Ribble Valley Borough Council
Housing & Development Control

Application no: **3/2019/0854**

Address: **61 Ramsgreave Road Ramsgreave BB1 9BH**

Proposal: **Construction of single storey extension to rear. Conversion of existing attached garage to habitable room and addition of pitched roof.**

Revisions	Drawn	Date
CLIENT MR & MRS I FERGUSON		
PROJECT 61 RAMSGREVE RD, BLACKBURN, BB1 9BH		
Drawn ST	Checked	Date MAY 2019
Scale(s) 1:50/100/500@A1		
DRAWING TITLE / No. PROPOSED DRAWINGS: PLANS & ELEVATIONS - 002

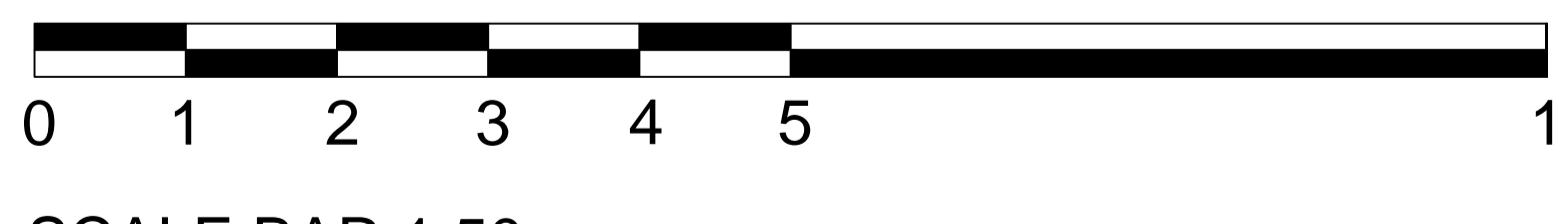
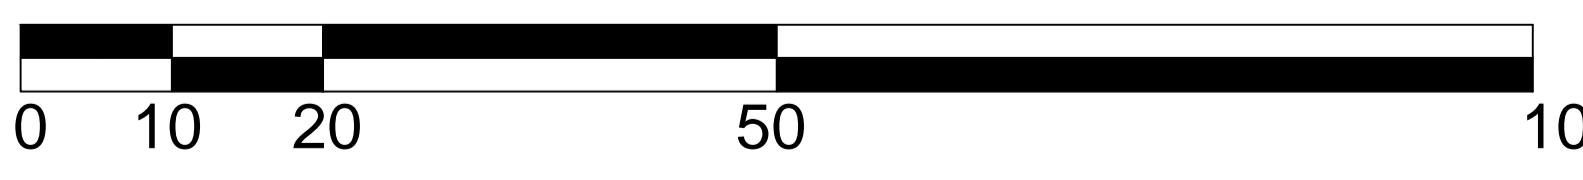
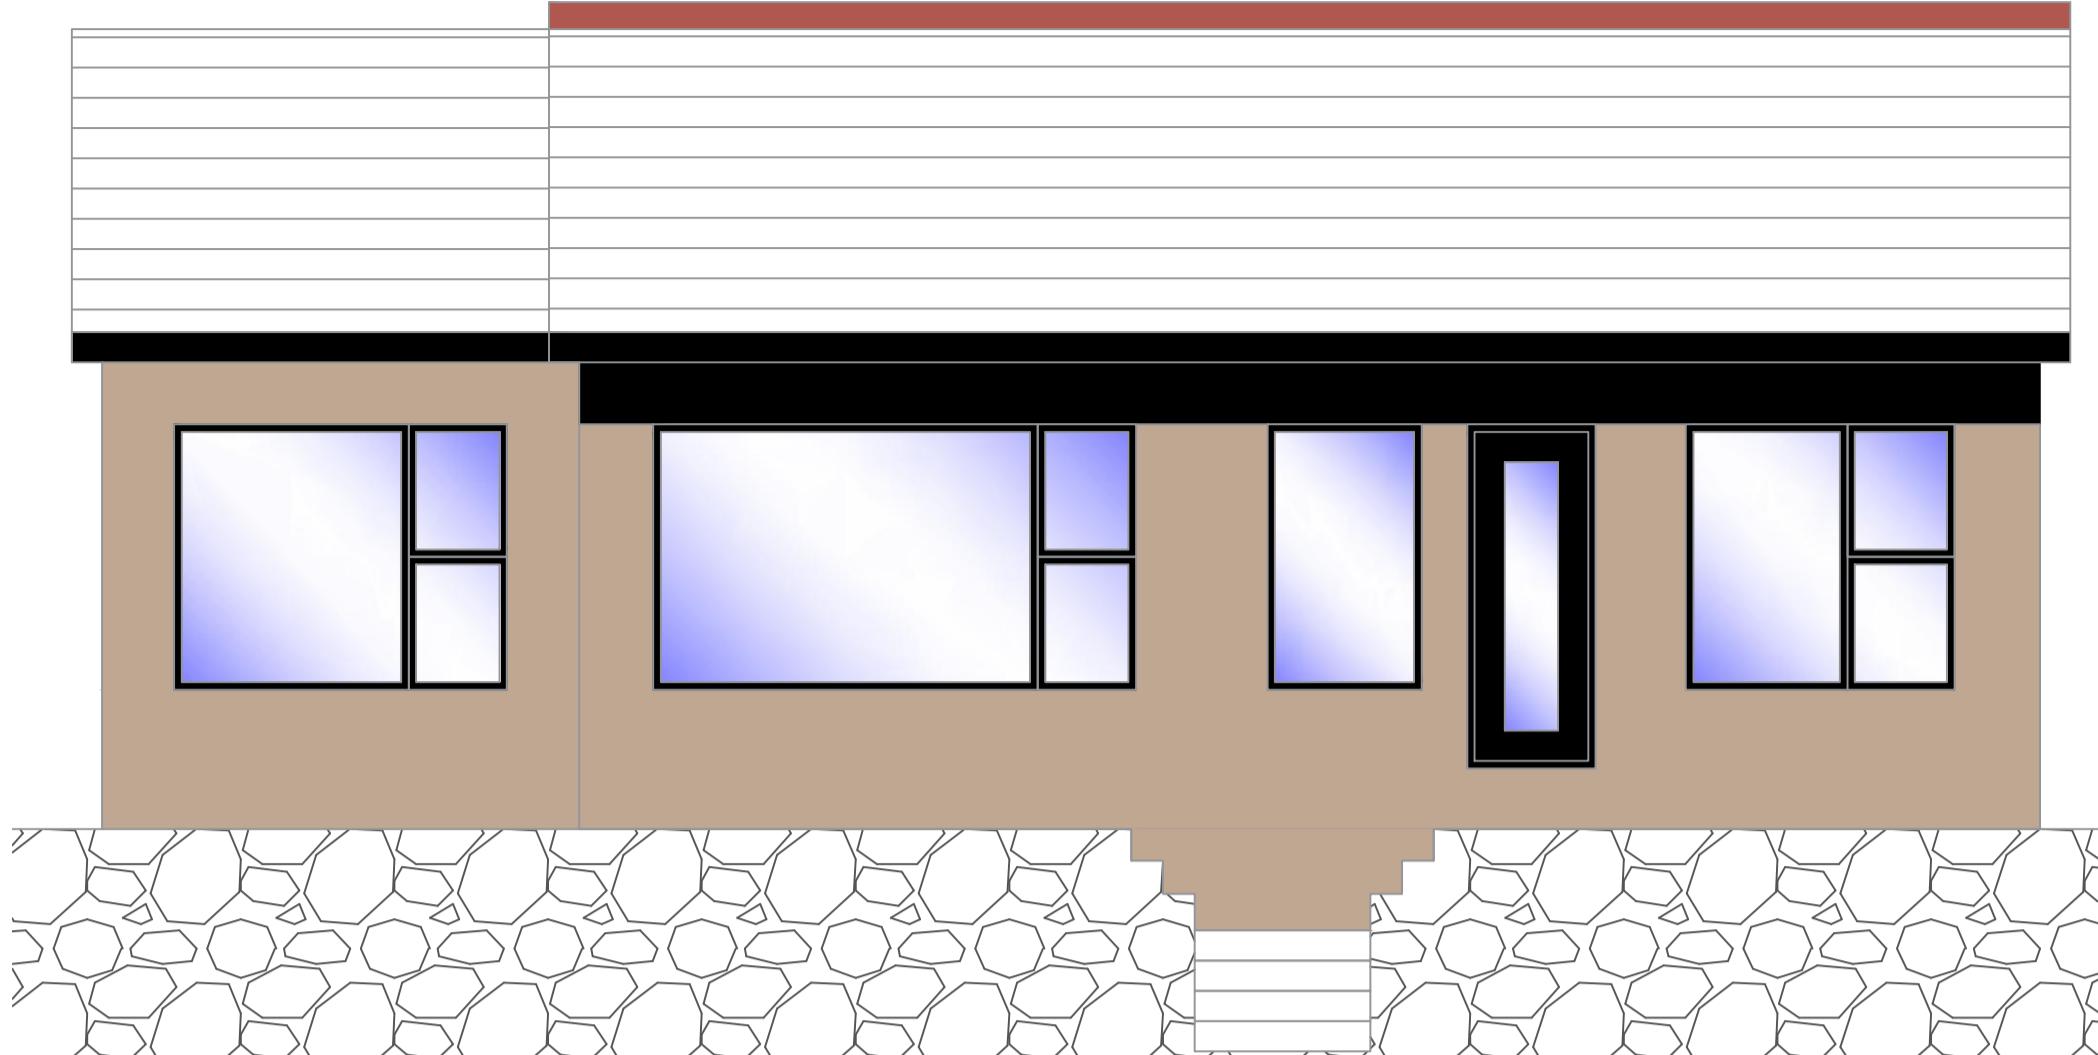
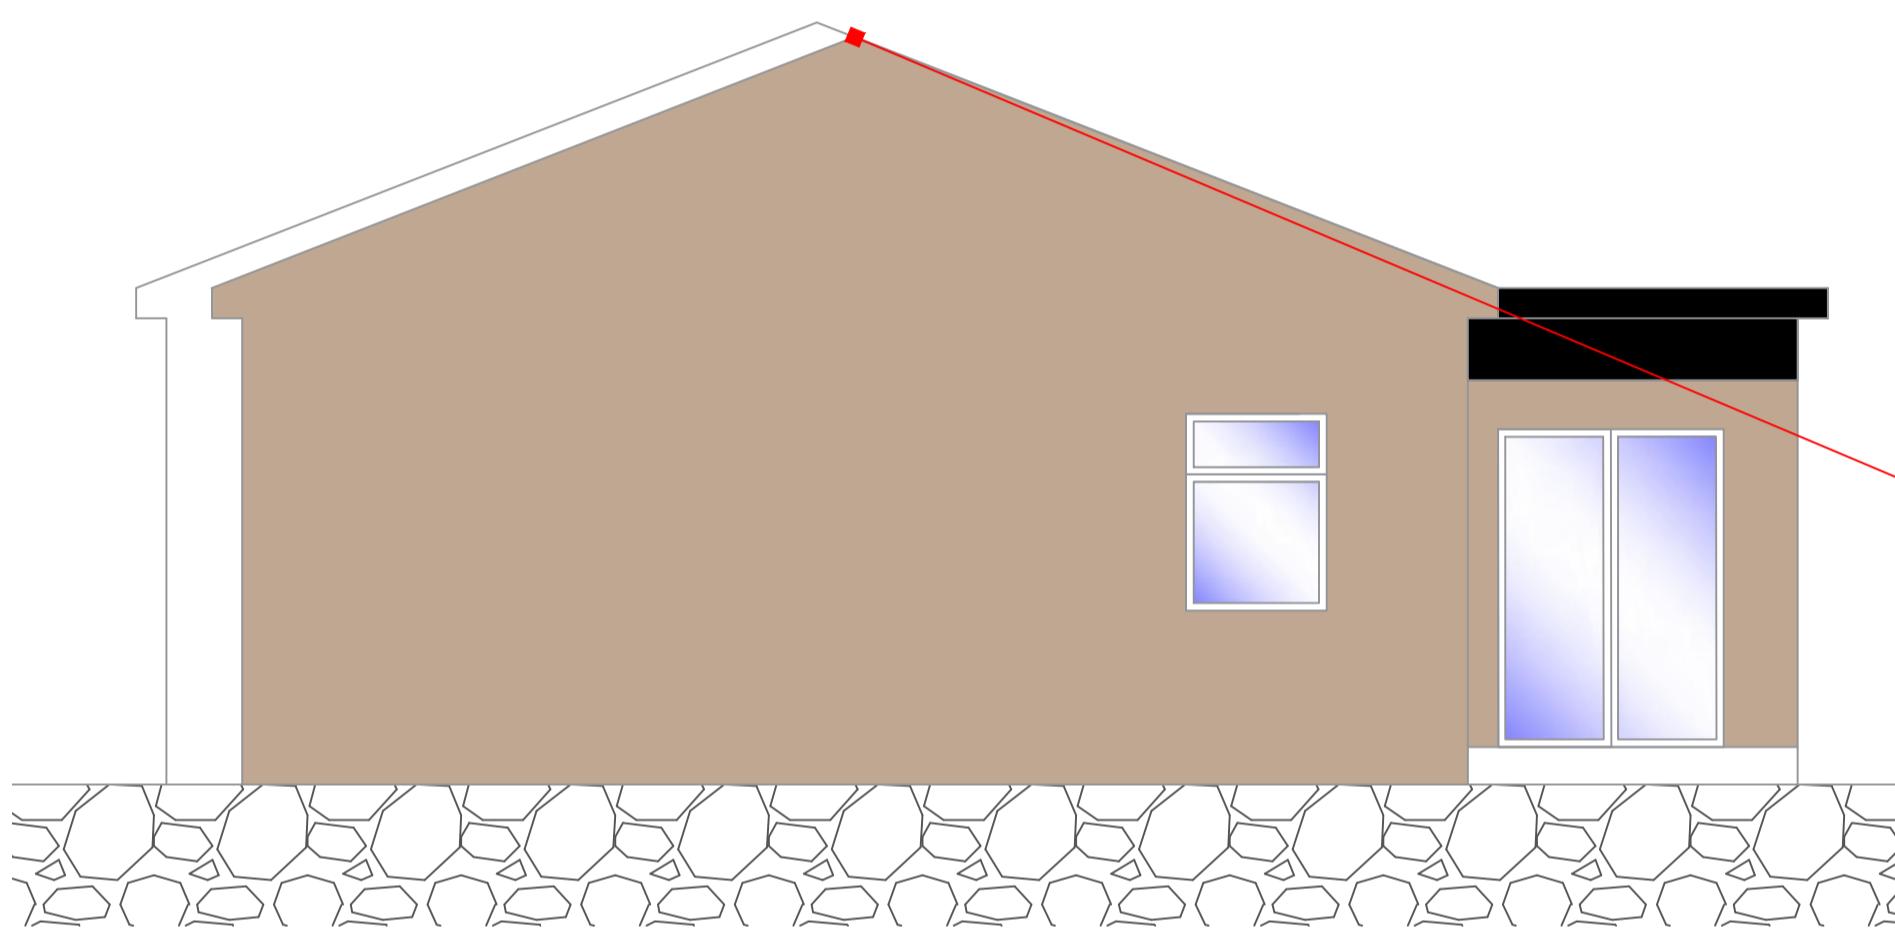
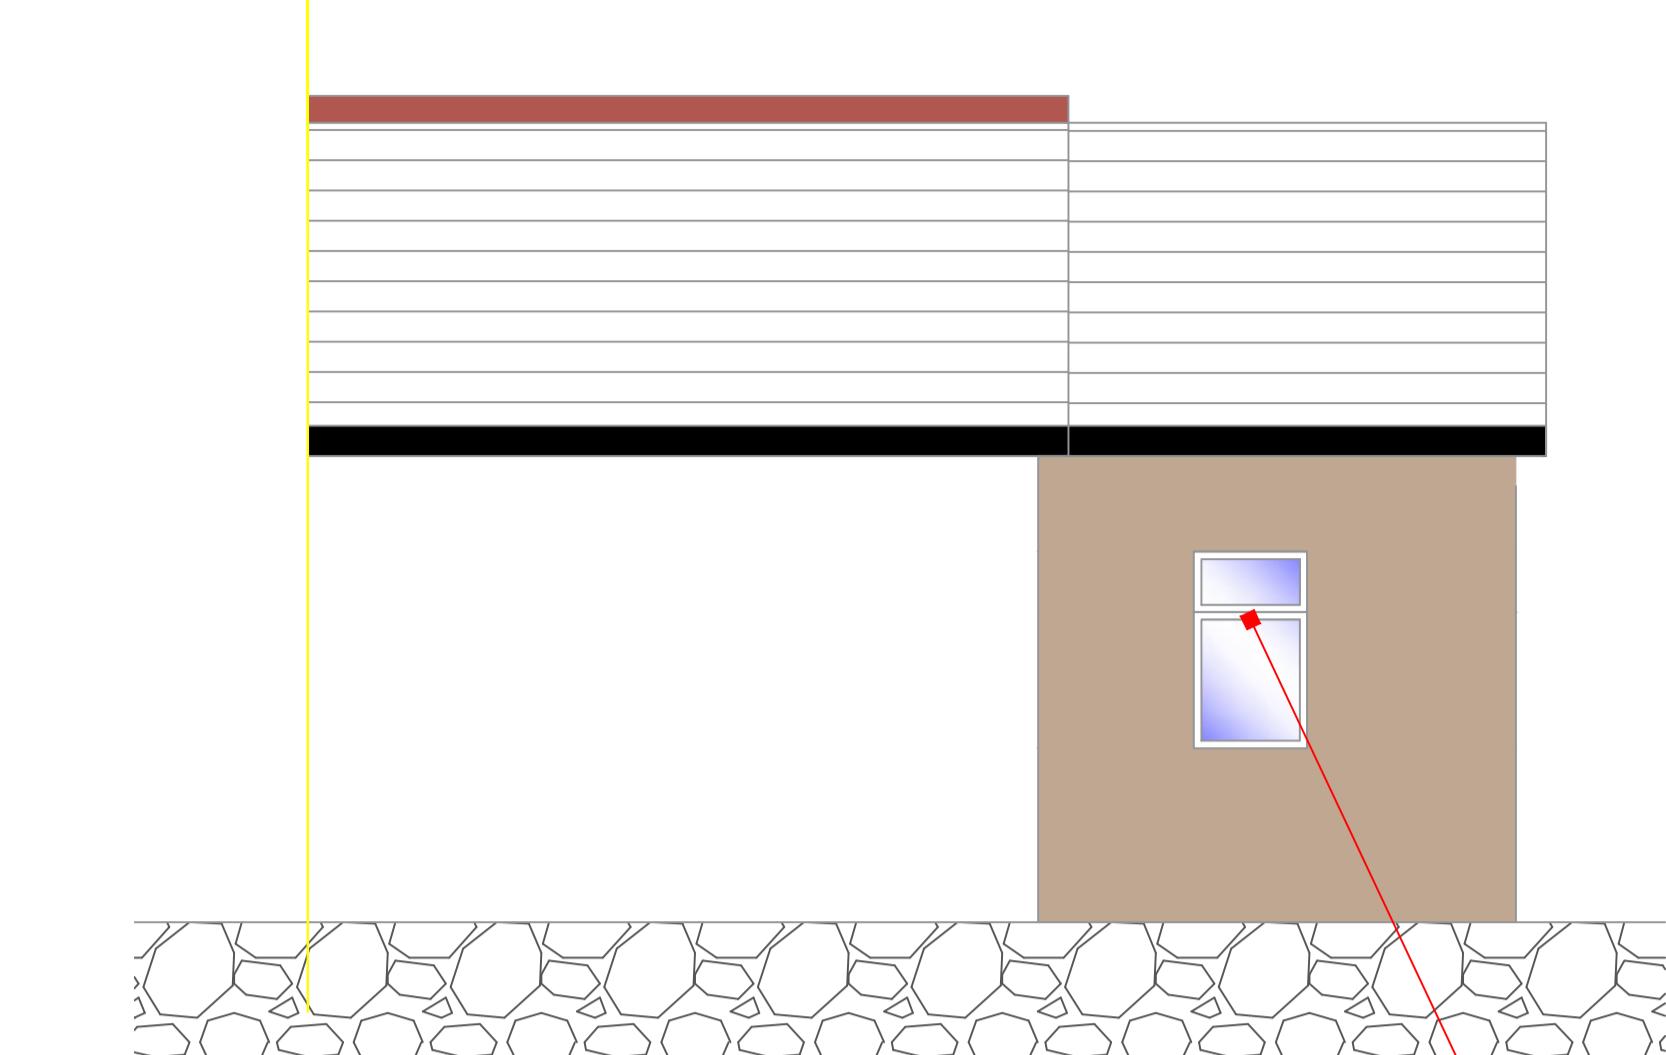
Whilst the parking provision will be retained as part of the proposal, there has not been any parking arrangements submitted as part of the planning application. The applicant proposes to convert the garage into a bedroom and whilst the frontage of the dwelling appears to have sufficient space to accommodate two parking spaces, the image of the small car on the existing driveway within the existing plans suggest that the existing parking arrangements fronting the dwelling does not comply with current standards and therefore the local highway authority would ask that the applicant submits a plan demonstrating the proposed parking arrangements.

The existing parking arrangements as detailed is considered substandard and could potentially result in vehicles overhanging the adopted pedestrian footway and causing obstruction to the detriment of pedestrian safety. Furthermore, the overhang of any vehicles within the adopted footway could reduce or obstruct the visibility of any vehicles exiting the neighbouring properties and thus the plans would need revising to provide the provision of sufficient parking in line with the required standards. The current dimensions for two perpendicular parking spaces whilst also allowing pedestrian access to and from the property is 6m x 5.5m.

Further, the Local Highway Authority will require the driveway to be constructed from an approved bound surface material and any potential surface water runoff from the driveway should be collected within the site and drained to a suitable internal outfall and therefore the applicant will need to provide measures to prevent any water from the driveways discharging onto the adopted highway.

The Local Highway Authority would require the plans be revised to address the above mentioned concerns.

1. Before the driveway is used for vehicular purposes, then the driveway extending from the highway boundary for a minimum distance of 5m into the site shall be appropriately paved in tarmacadam, concrete, block paviours, or other approved materials. **Reason:** To prevent loose surface material from being carried on to the public highway thus causing a potential source of danger to other road users.
2. The surface water from the approved driveway should be collected within the site and drained to a suitable internal outfall. **Reason:** In the interest of highway safety to prevent water from discharging onto the public highway.
